Application for a non-material amendment following a grant of planning permission.

Description of Development
Single storey front & rear extensions, raising of existing garage roof as part of conversion of garage & front canopy. This application may affect the character & appearance of the Craigweil House, Aldwick Conservation Area.

Reference number:	AW/294/19/HH
Date of decision	10/01/2020

White render on front of house

NON MATERIAL AMENDMENT FOR AN/294/19/H+1
WHITWORTH. 54 KINGSWAY, CREAWEIL, ALDWICK, PO214DN

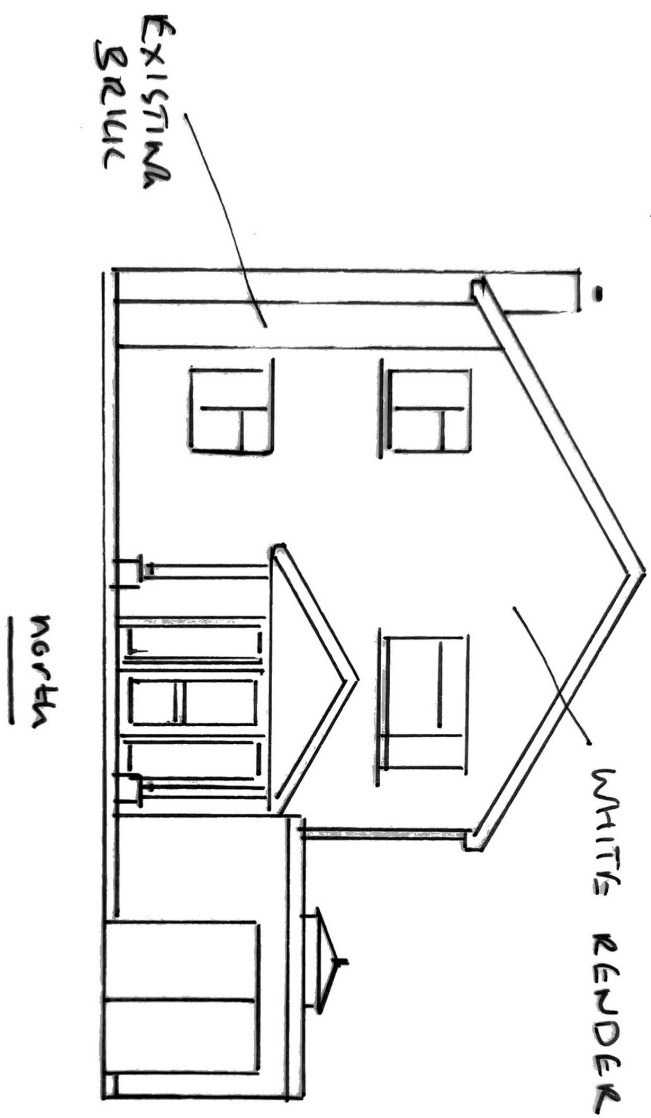
Due to material shortages the approved wood cladding is not currently available to us.

We ask that the portion that was due to be wood cladding may now be white render, to match the majority of the proposed North Elevation that has been approved.
